Our ref: DOC20/569521
Senders ref: SSD-10352

Subject: EES comments on Response to Submissions for Moriah College Redevelopment – Queens Park campus – SSD-10352

Subject: EES comments on the Response to Submissions for Moriah College redevelopment – Queens Park campus – SSD-10352

Figure 8. Location of Fire Management and Buffer Zones

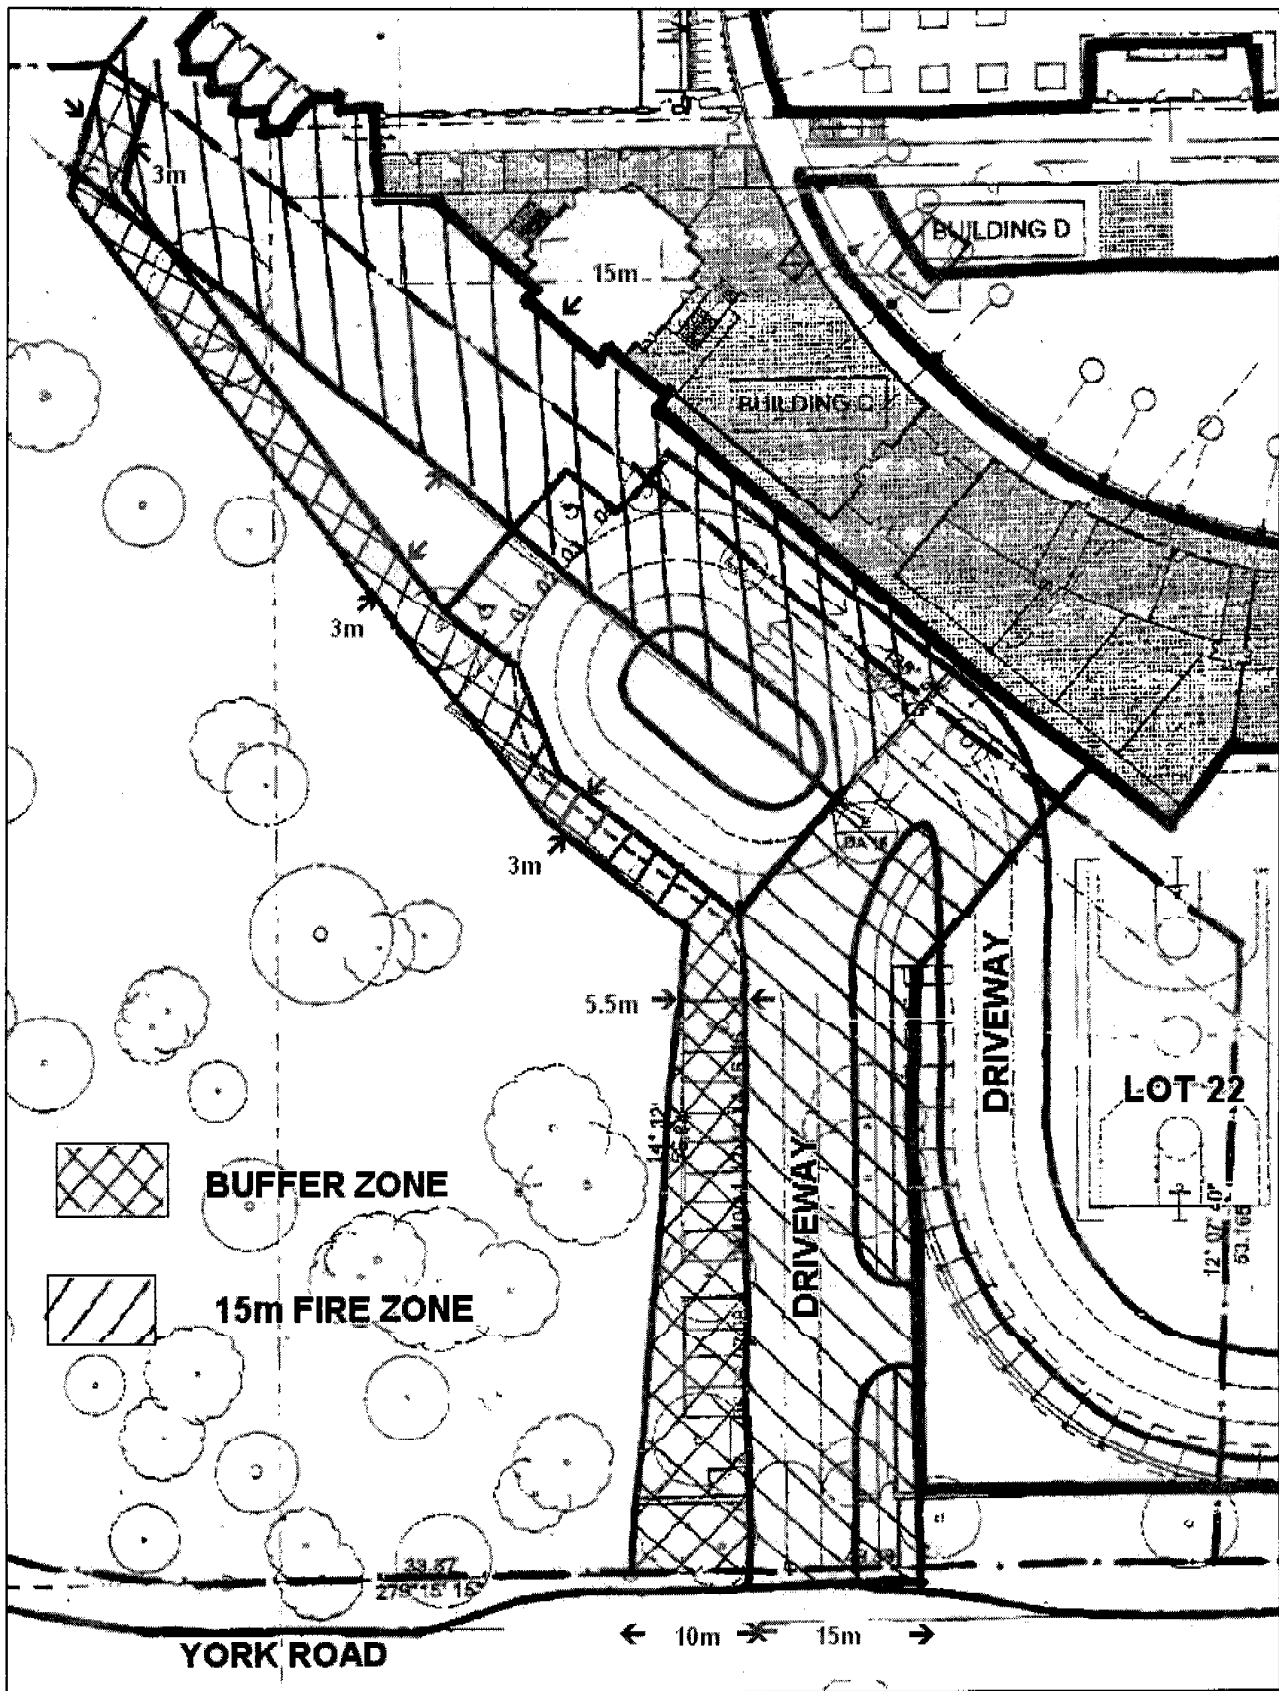
It is noted that the “vegetation management plan” (in condition 2 of Annexure 1 of the approval) is the UBM VMP of October 2020 and that the “map” referred to (in condition 3) is the same as Figure 8 of the UBM VMP.

The current SSD application disregards these requirements, particularly at the southern (York Road) end where the buffer zone is required to be 10 metres wide, with proposed lower and upper ground level development proposed right up to the boundary with Lot 23.

- ***The conditions of these prior approvals apply***
- ***The buffer zone be reinstated to the configuration, width and condition required by those prior approvals, including removal of any encroaching structures and hard surfaces***
- ***With the exception of works necessary to achieve the reinstatement of the buffer zone, earthworks, soil disturbance or machinery access be prohibited from the buffer zone.***

Figure 3 – Required vegetated buffer zone – Annexure 2 of EPBC 2002/575

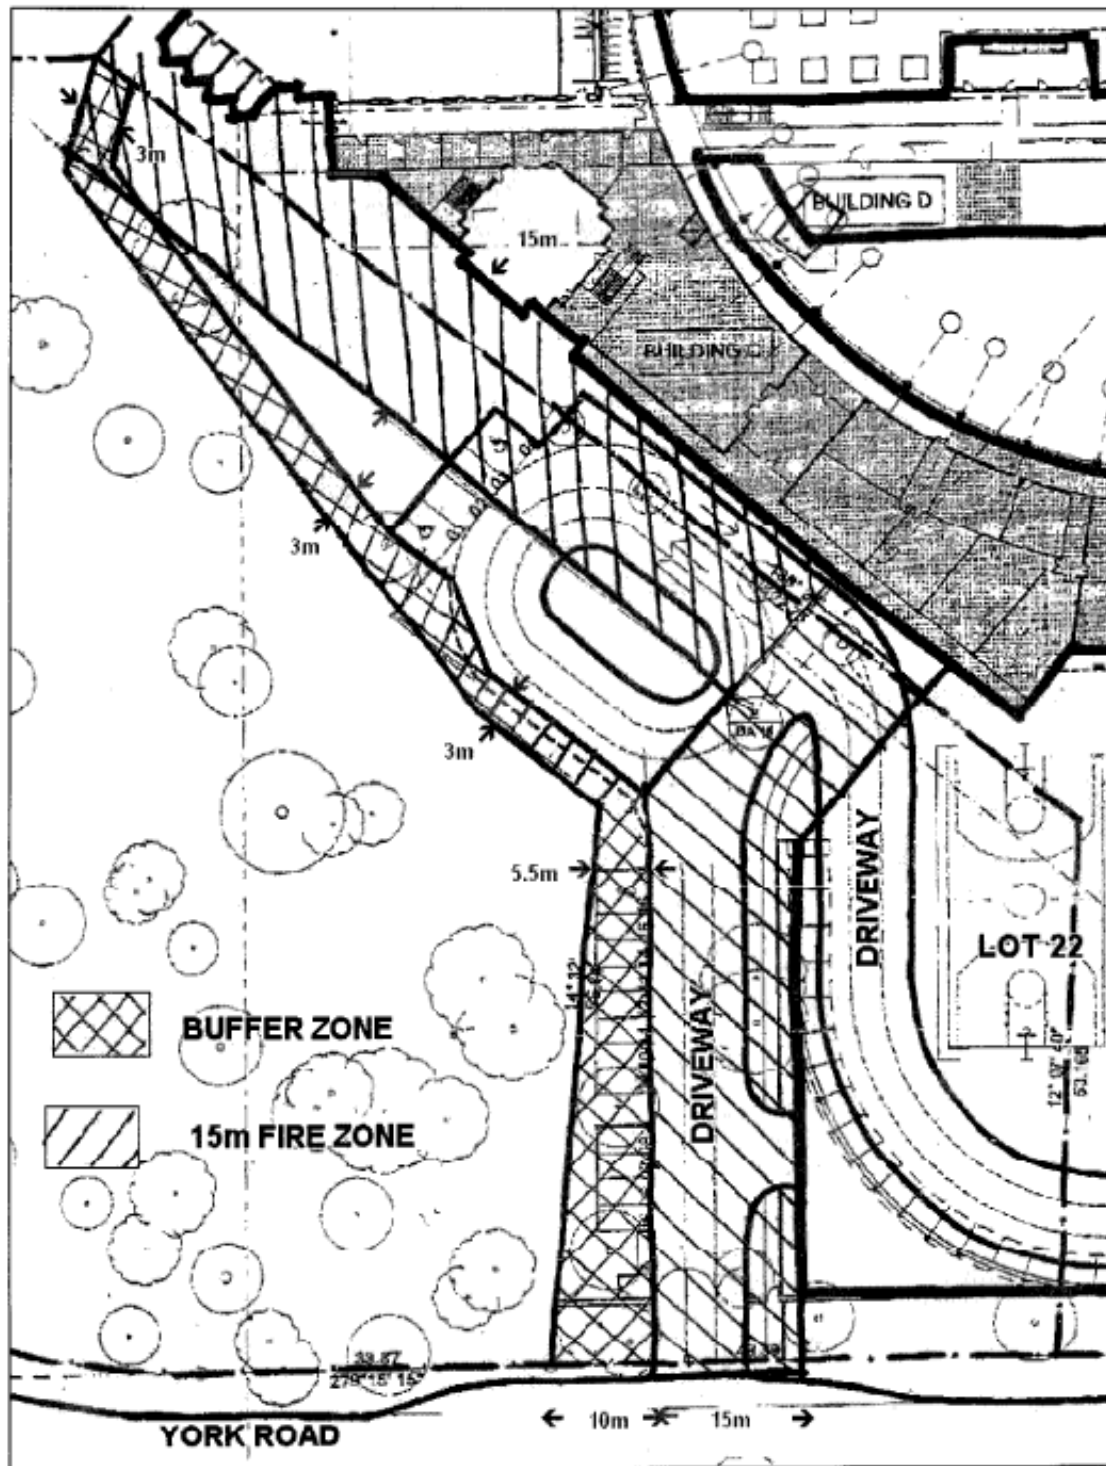
EES also notes from examination of aerial photography that existing buildings and hard surfaces within Lot 22 may be encroaching within the buffer zone required by those conditions.
